Application No: LU/136/22/HH
Site Address: 12 Reef Close Littlehampton BN17 6QG
Description of works: Two storey side extension and single storey side extension with alterations to fenestration and demolition of attached garage.

Thank you for your internet representation made on 9th June 2022 which has been recorded as an objection with the comments as follows:

Drawing P10 May 2022 Scale 1:100 / 1:500 @ A3
Planning Drawing - Ground Floor & Block Plan & Elevations

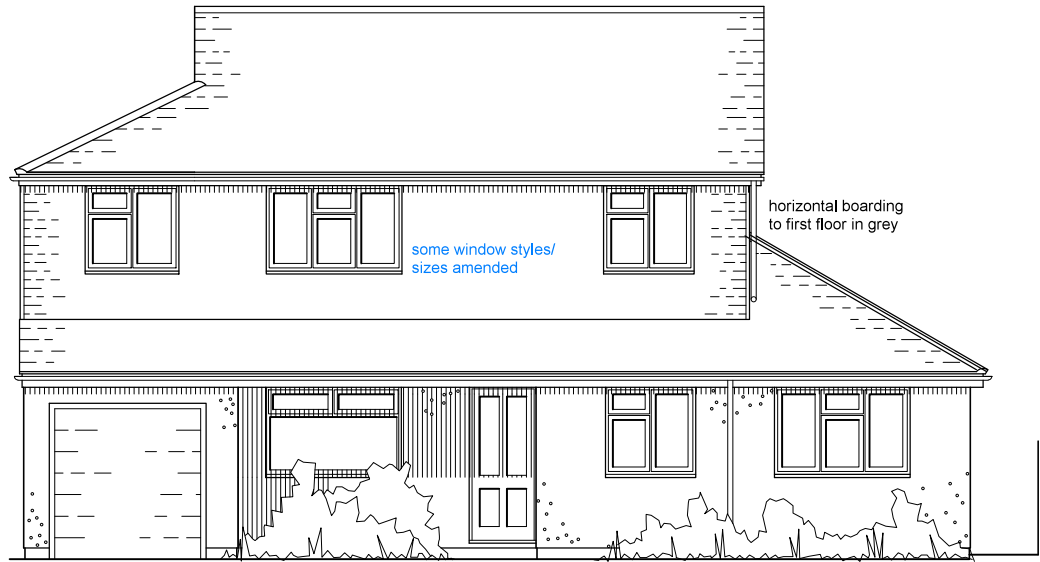
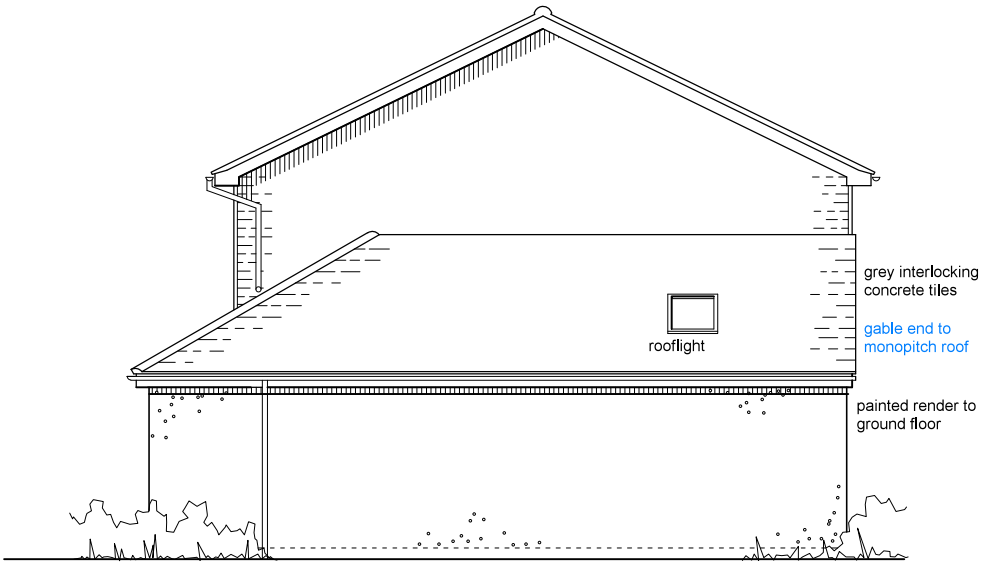
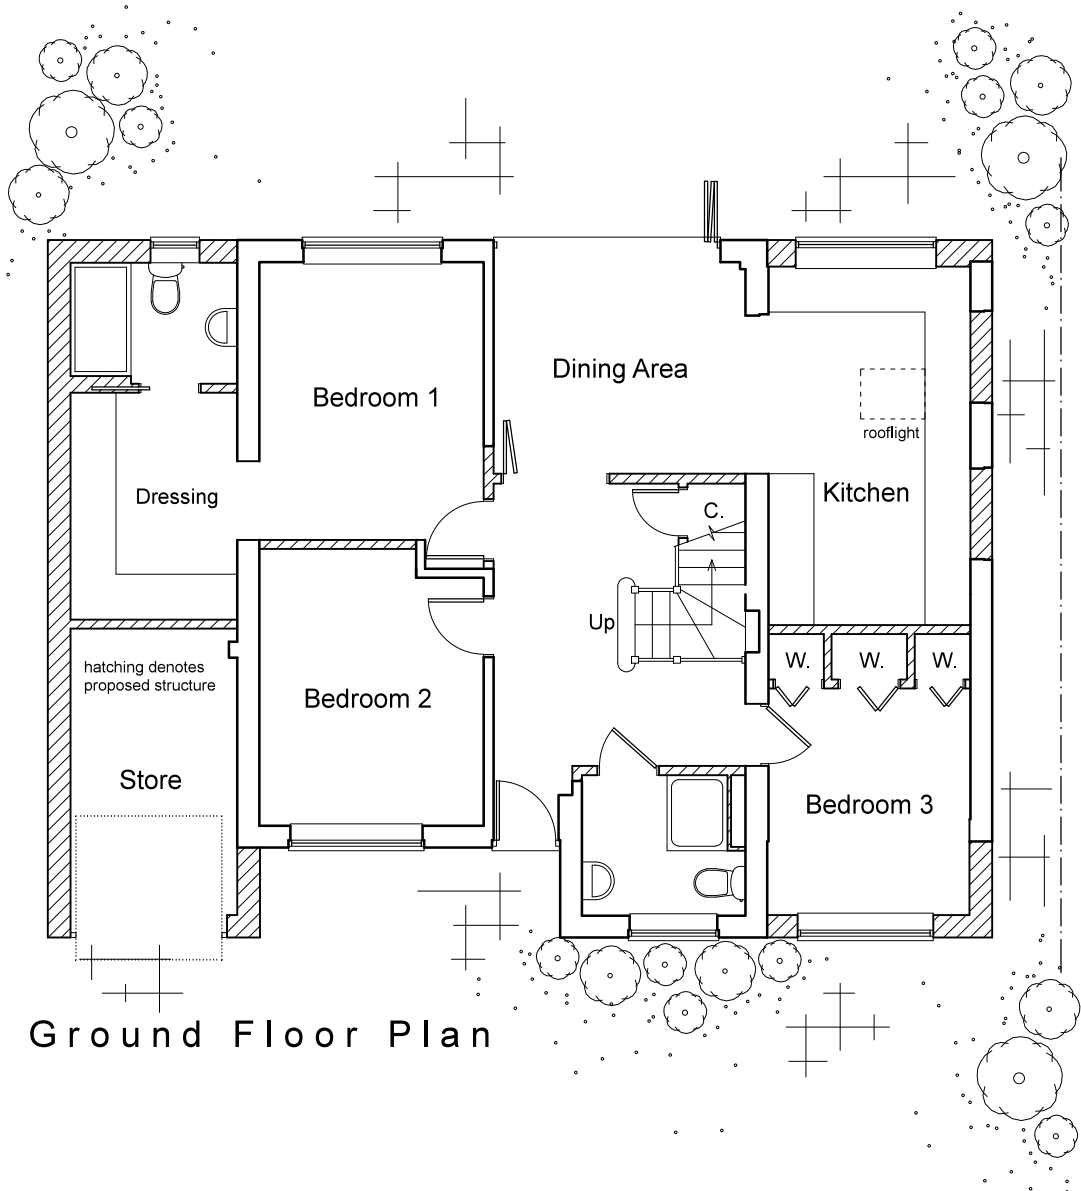
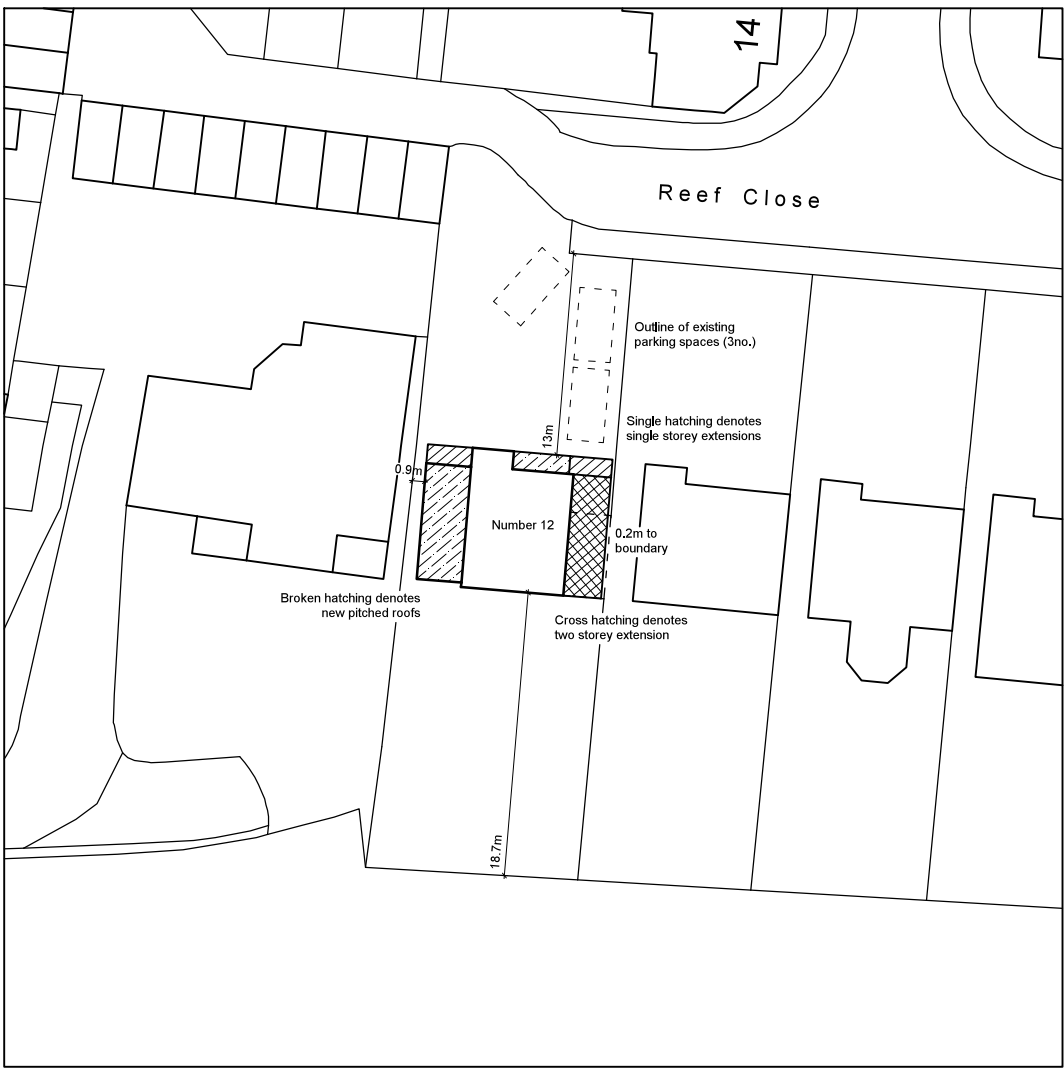
We submit our second objection to these proposed extensions which is that they will be detrimental to the character and appearance of Reef Close. The original concept and design for this area was to maximise the openness between the detached houses whereas the double storey extension creates a solid, more crowded appearance.

Building work has already started which confirms our original concerns regarding the scale and overdevelopment of this property, which is not in keeping with the other detached properties.
